2026/0014

**Proposed steel containers to be converted into a private bar with car sales offices above.
(Retrospective)**

2 SITE PLAN
1 : 500

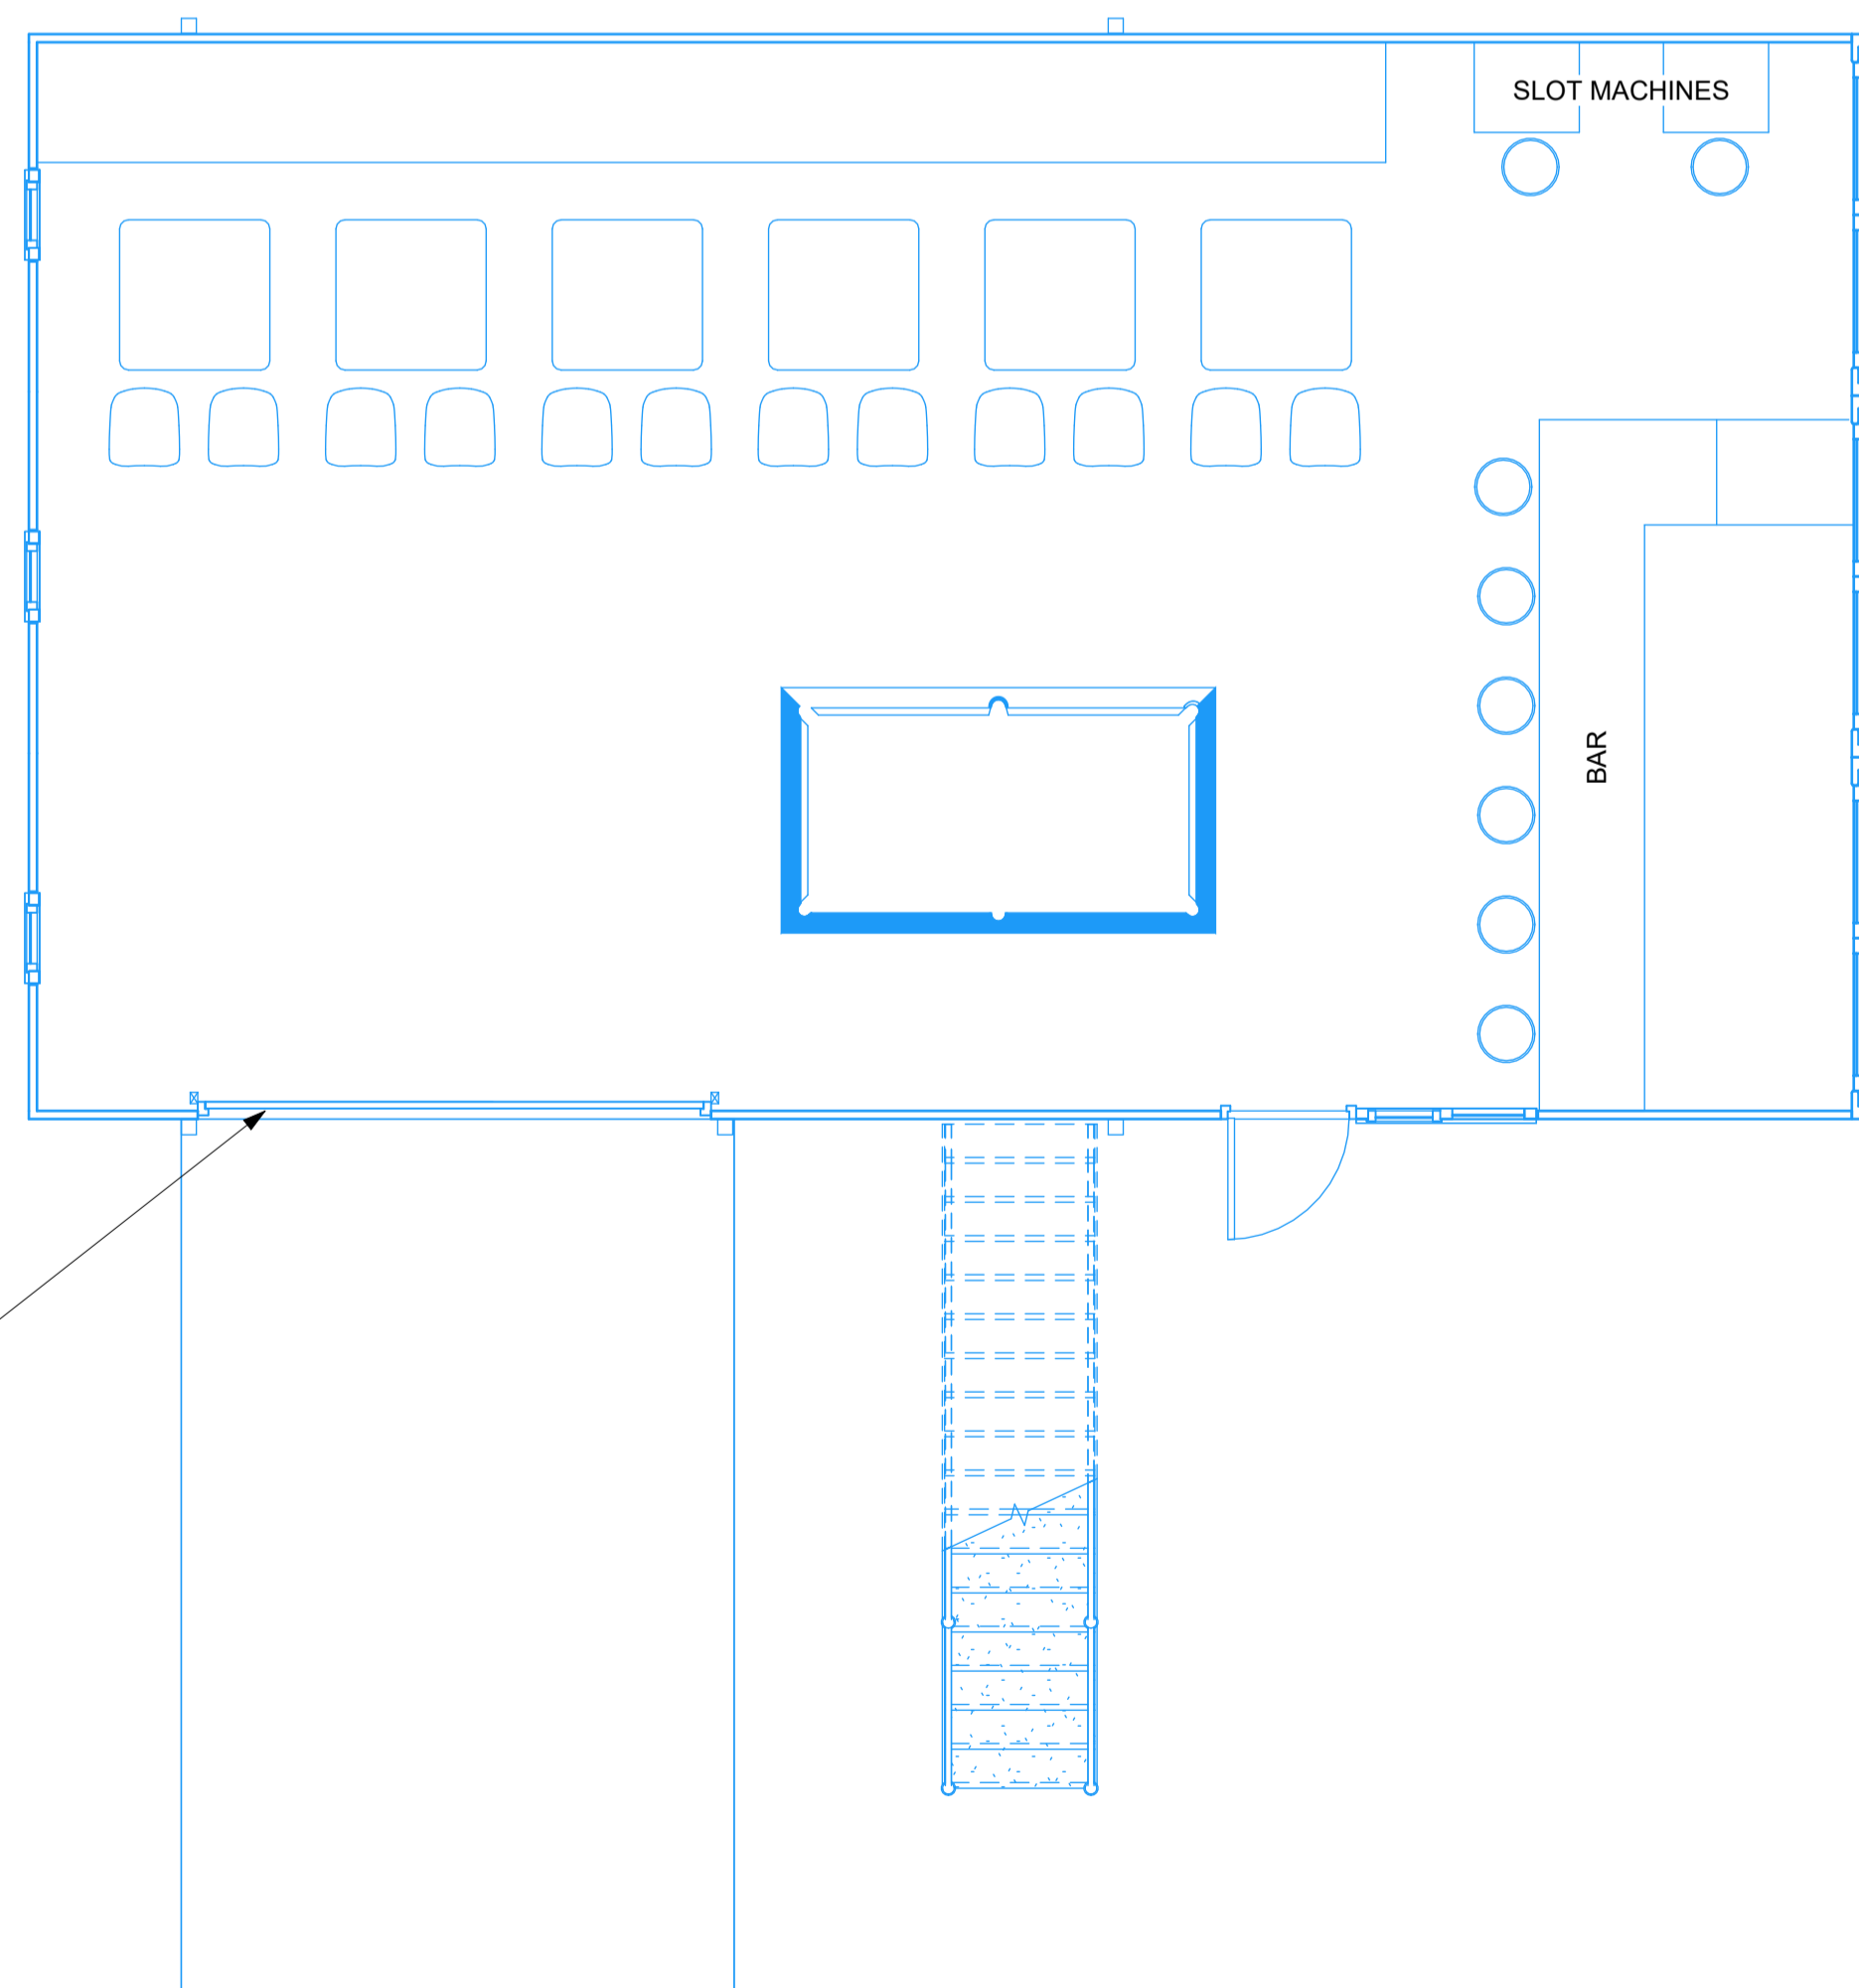
Highways DC advised that insufficient information had been submitted to enable a meaningful assessment of the proposals. The submitted site plan contained a hand-drawn indication of ten parking spaces, however this does not correspond with the reality of the site layout when a site visit was undertaken or when viewed from google earth . Highways DC would not support approval of the site without further accurate details of parking provision, including the location and dimensions of vehicle parking spaces and information regarding their allocation between employees, customers of the car sales business and visitors to the private bar. Furthermore, no information has been provided in respect of the likely visitor numbers associated with the private bar use to allow Highways to make comment on potential trip generation.

In addition, it was noted that no information had been submitted regarding vehicular and pedestrian visibility from the site access and that the achievable visibility to the west of the access is significantly below the standards set out in Manual for Streets. Whilst a visibility splay of approximately 2.4m x

11m would ordinarily be required for vehicle speeds as low as 10mph, the Highway Authority advises that only a visibility splay of approximately 2.4m x 3.2m can be achieved. This is substantially below recommended standards and raises concerns regarding the ability of drivers to safely exit the site.

Moreover, no details have been submitted regarding the construction standard of the access, nor any details demonstrating that the access and hardstanding areas are appropriately drained to prevent surface water discharging onto the adjacent highway.
